Read
Burnley

13 January 2021

Re: Planning Application No. 3/2021/0011

roof

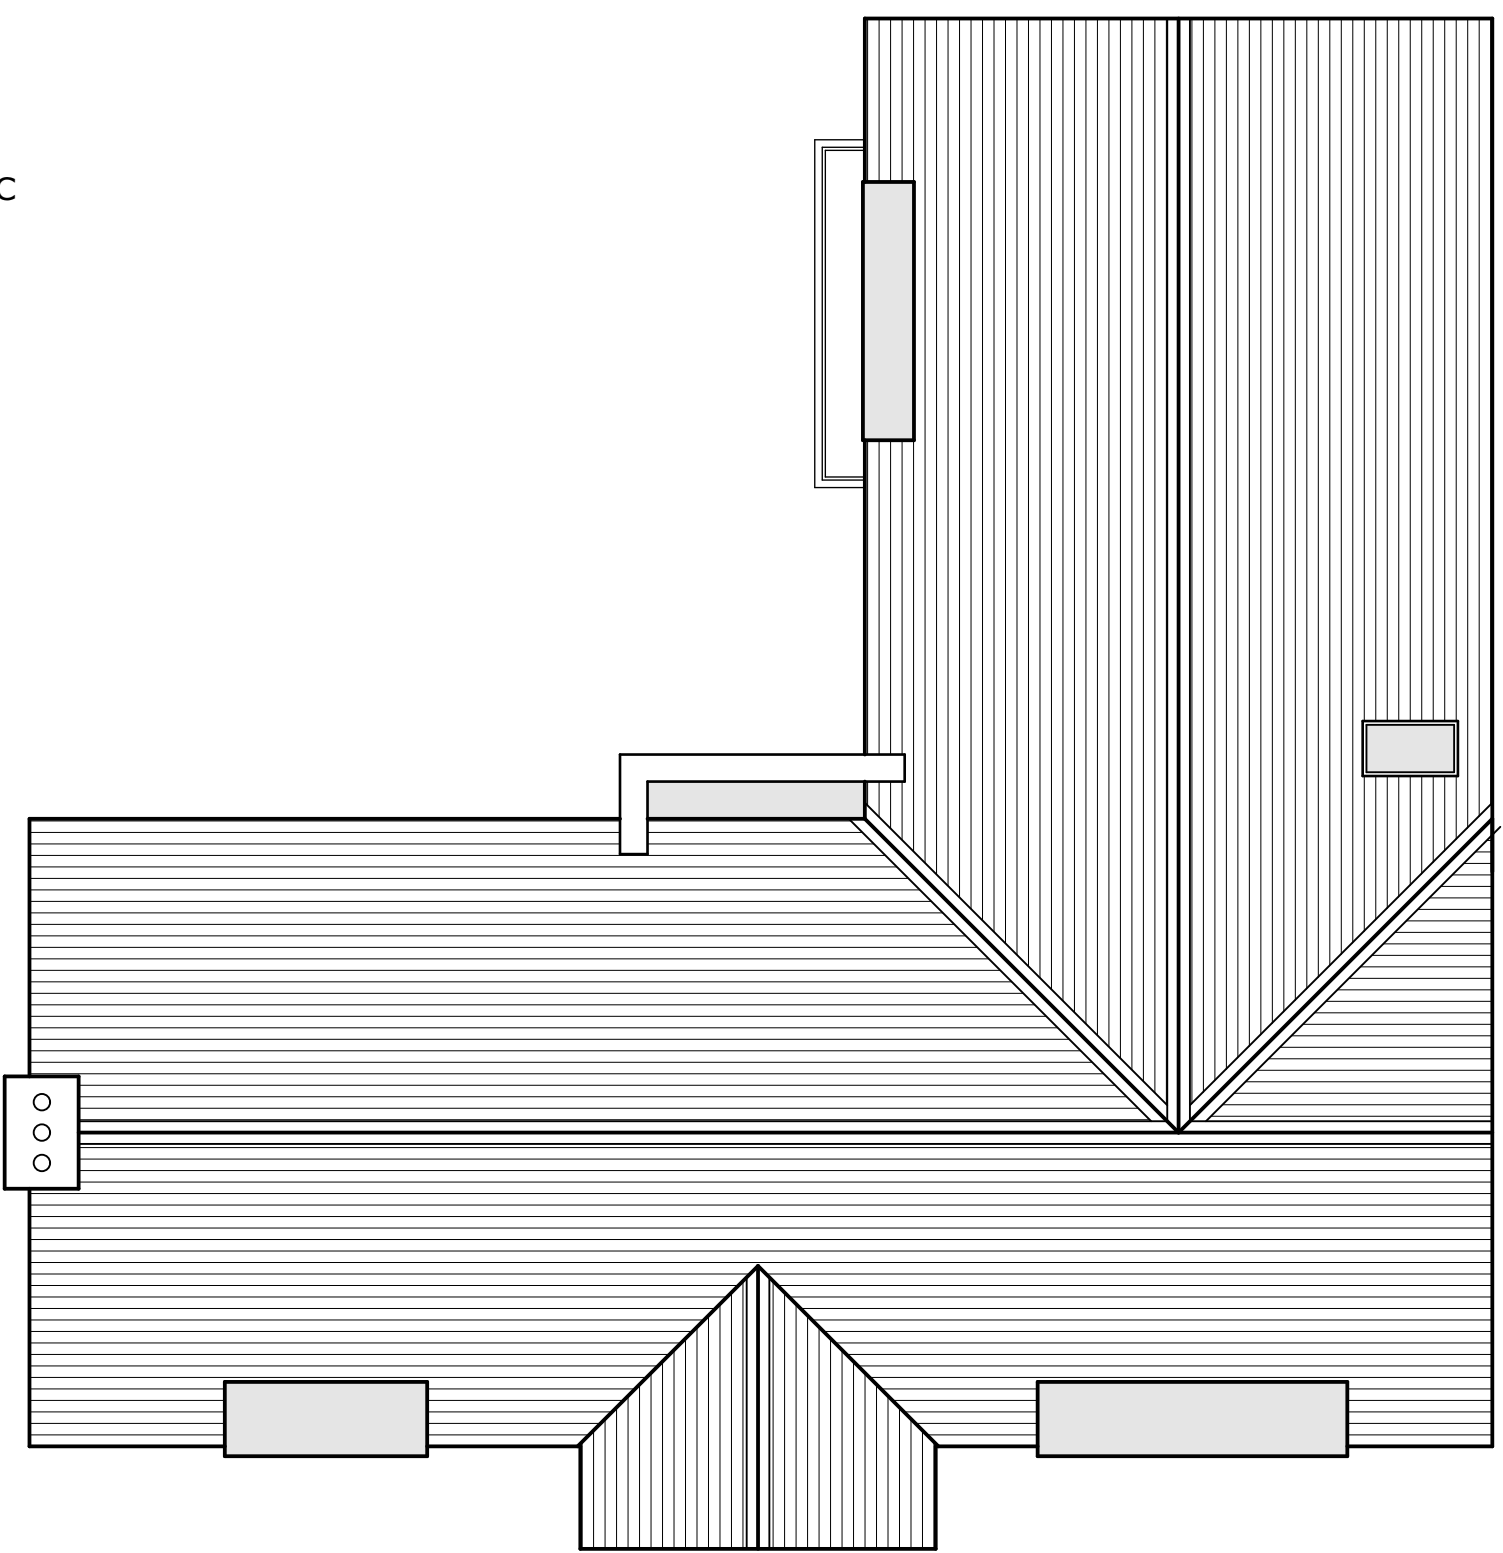
3. Overlooking and loss of privacy – the proposed development is at a higher elevation than our property which in winter, when the trees lose their leaves, offers a direct vantage point into our garden, main reception room and master bedroom windows. We had presumed any windows adjacent to our property would be limited, or frosted for privacy if development took place?

4. Balcony – A stipulation of our own relatively recent planning consent when we extended our property and created a balcony which overlooks our neighbour's garden, in a much less intrusive fashion, was to screen visibility with opaque glass. While we recognise each planning application is considered on its merits we would be looking for some consistency in the planning departments decision making. As this particular solution doesn't appear possible with the current proposed balcony positioning, we would suggest that the proposed balcony in the master bedroom face directly into Hammond Ground through the other window rather than the side facing adjacent buildings and gardens with opaque glass being used on the side panels to provide us with adequate privacy.

Title:
TREE CONSTRAINTS PLAN
In Relation to Proposed Detached Residential Property

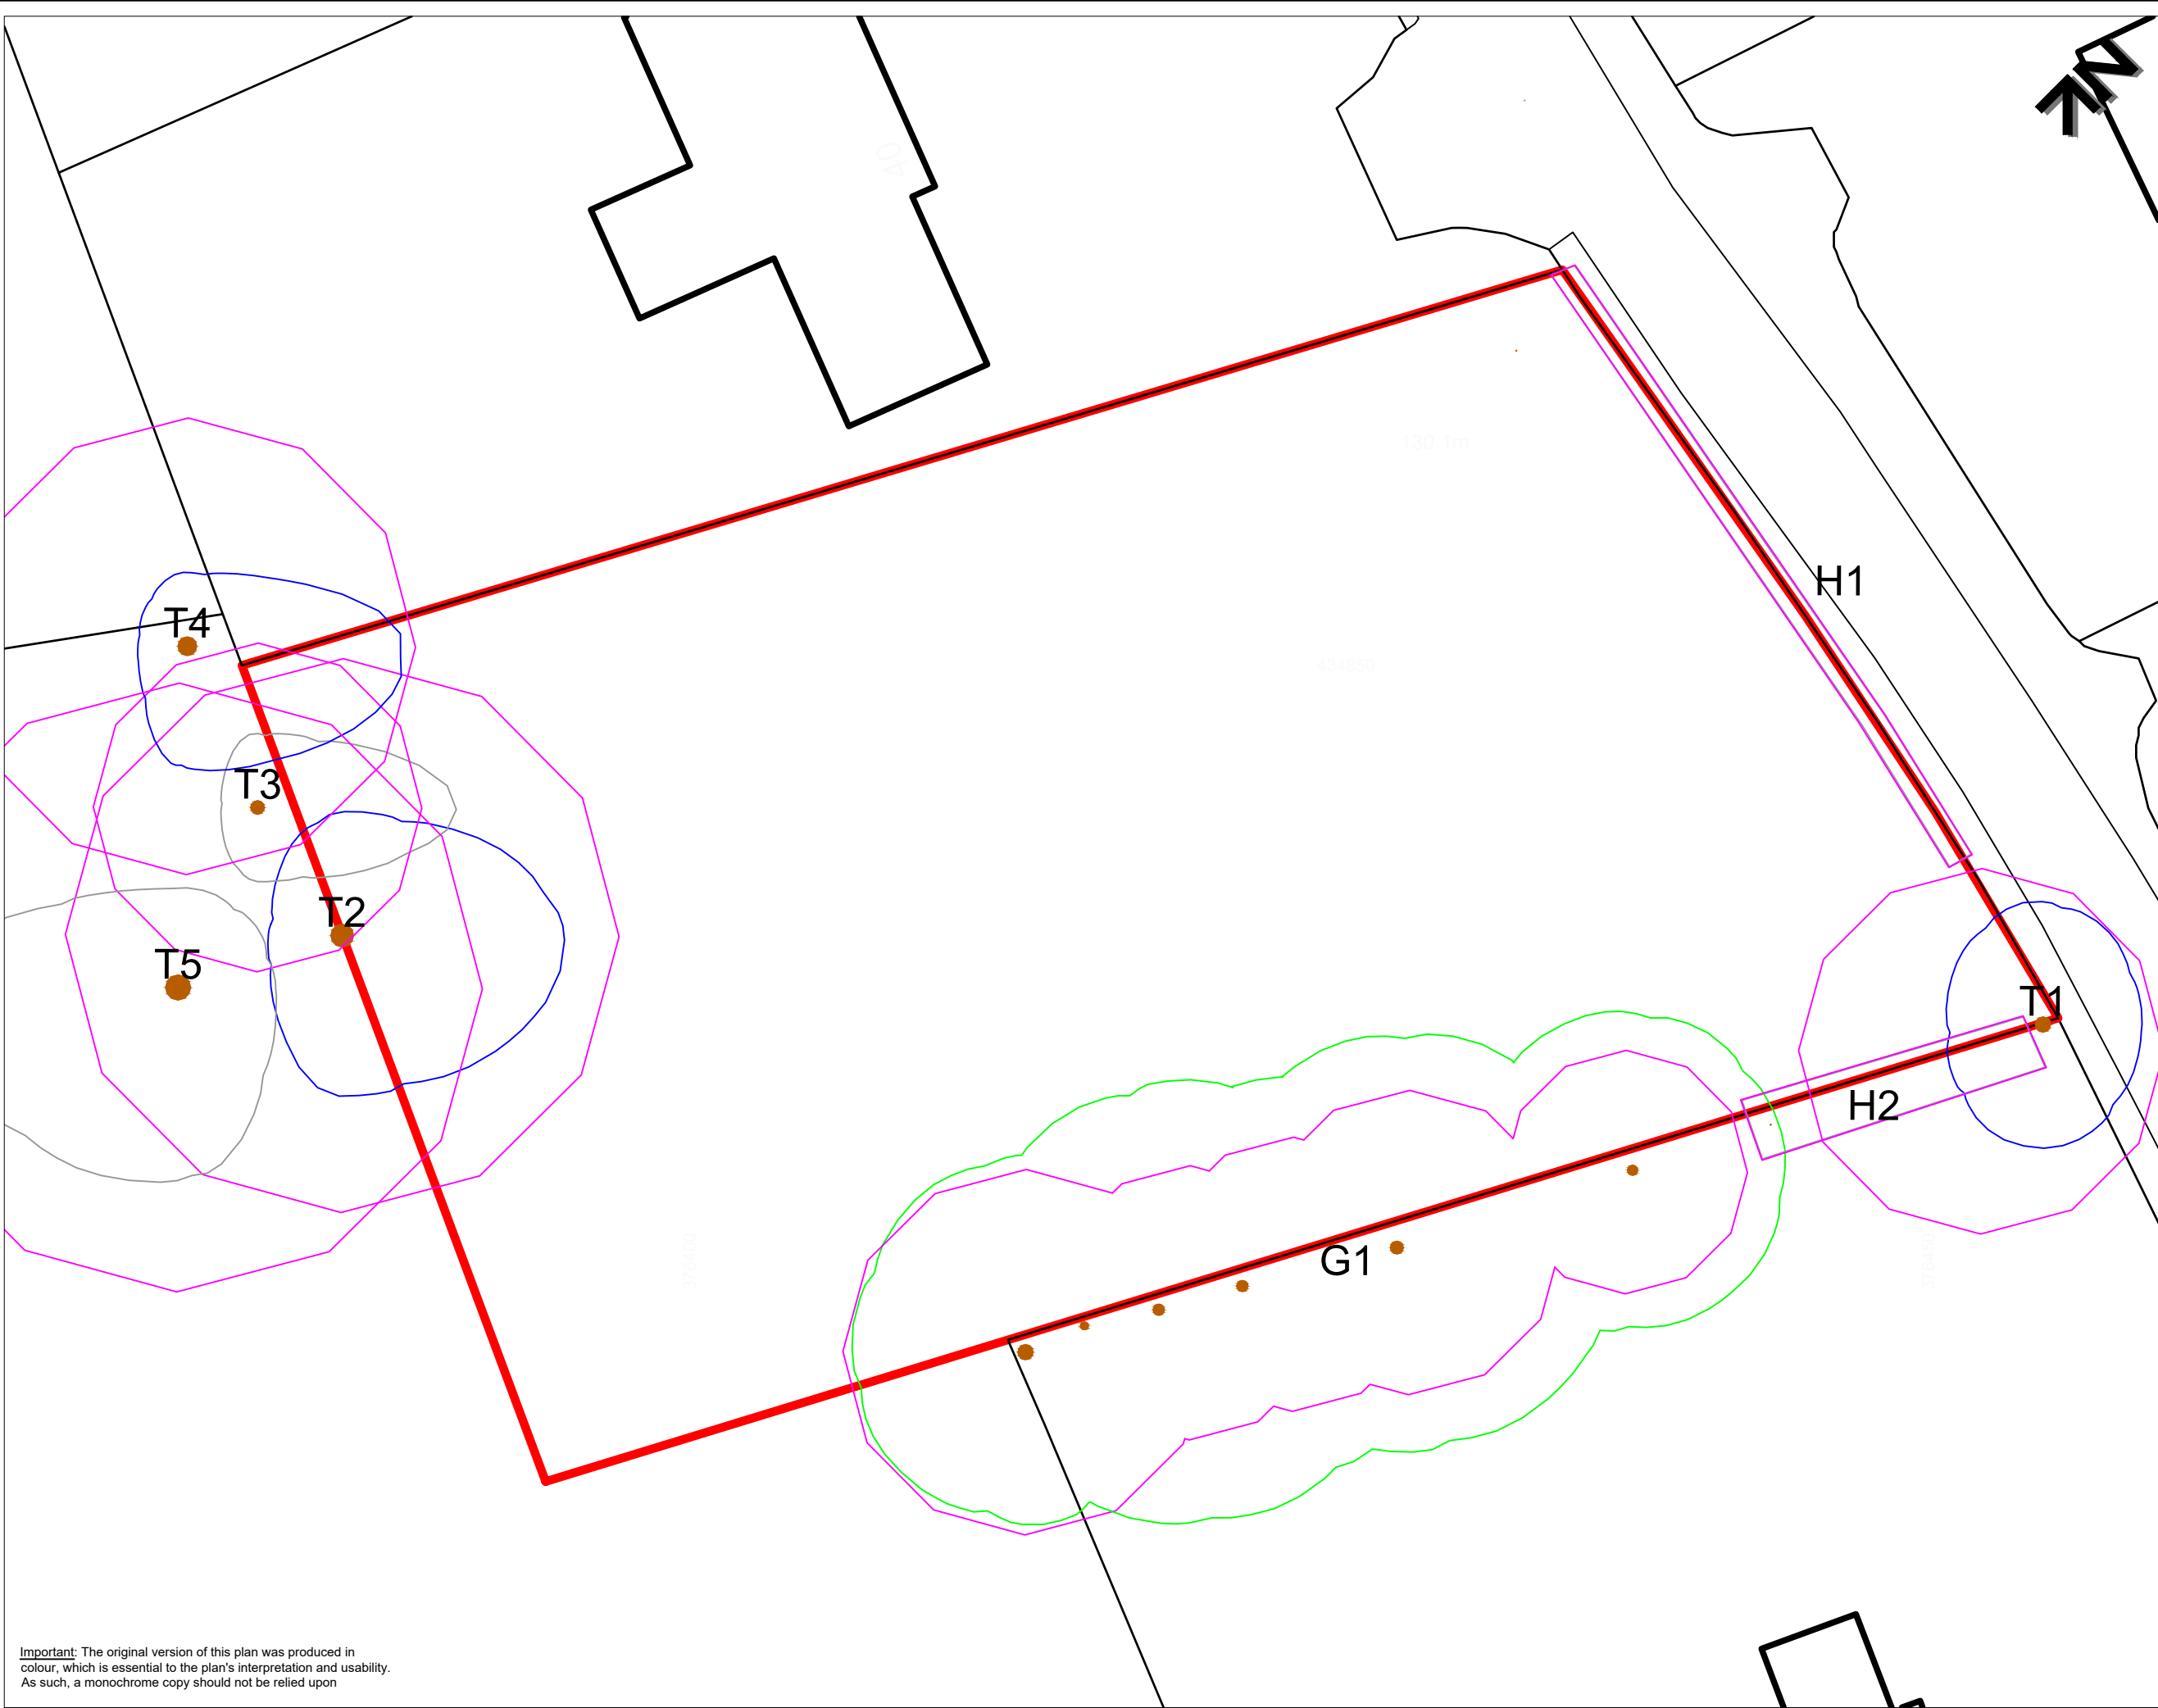
5. Trees - we have eight very large deciduous trees on the edge of our property directly adjacent to the proposed development and mark the boundary. These trees are at least 60 ft high and the oldest amongst them I estimate at over 150 years. The canopy extends over 20 feet into the proposed build plot. I am pleased to see the tree survey results in response to my previously raised concerns and the protection suggested during building work, but I notice the plans now include tree planting directly adjacent to the already established tree line which would undoubtedly disturb the root system. We would suggest that this element of the design is revisited.
